From: Simon Davis
Sent: 03 January 2019 16:32
To: Planning.Responses
Subject: FW: AW/198/18/PL
Attachments: 1685-2.02 rev C Proposed plans and elevations.pdf

From: Dawn Appleton <[REDACTED]>
Sent: 02 January 2019 09:33
To: Simon Davis <[REDACTED]>
Subject: RE: AW/198/18/PL

JOB NO.	DRAWING NO.	REVISION
1685	2.02	B

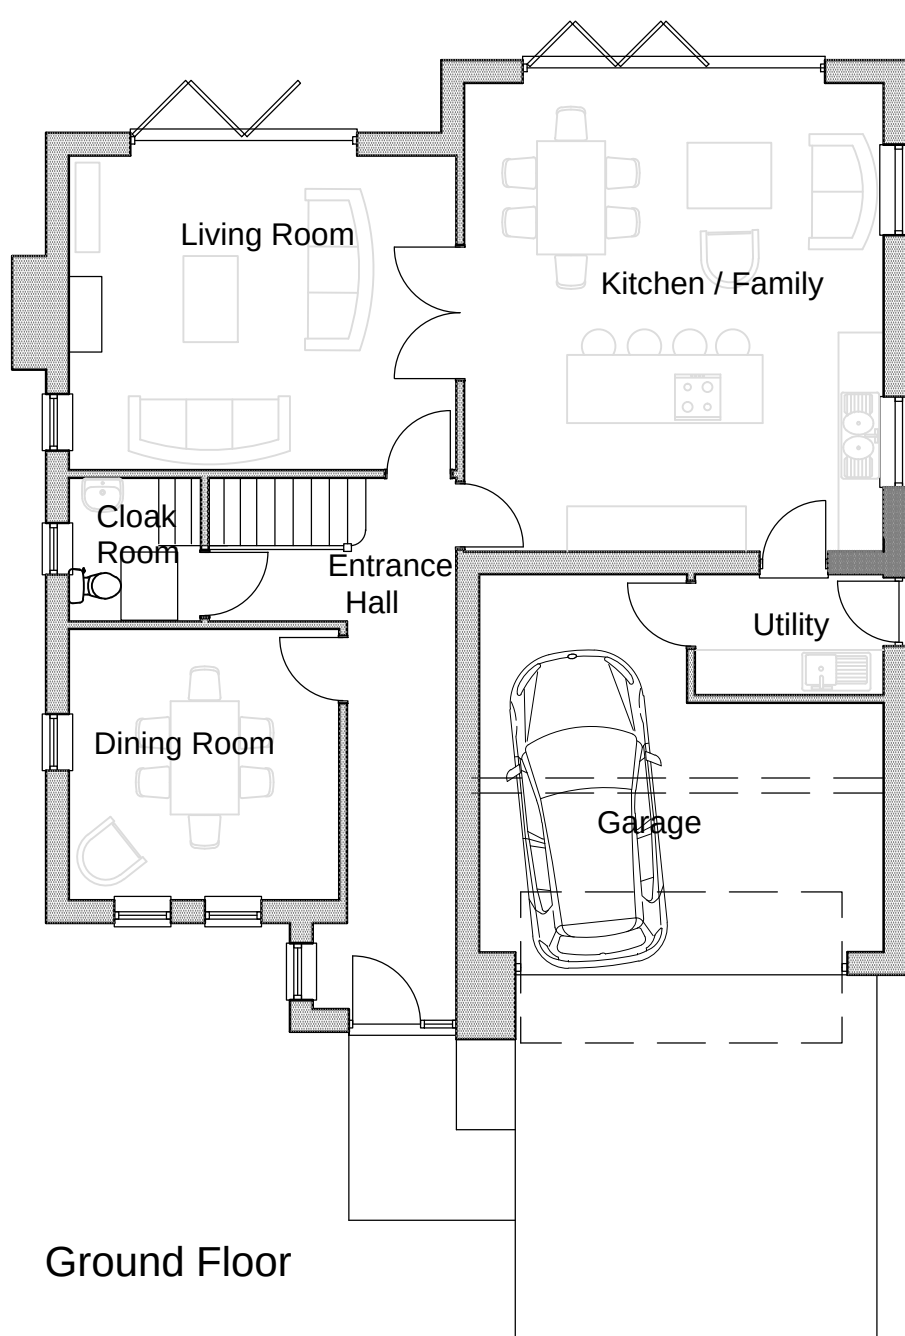
I have had a look again at the application this morning. I am not prepared to comment to the acceptability of the proposal in an email but I am happy to discuss over the phone. However, I would request one small change to the design of the house – I would like to see a privacy screen to the SE side of the front balcony. This should preferably be in the form of an 'extension' of the flank wall upwards to a height of 1.7m above the balcony ground level. However, as an alternative I would accept a non-reflective obscured glass screen.
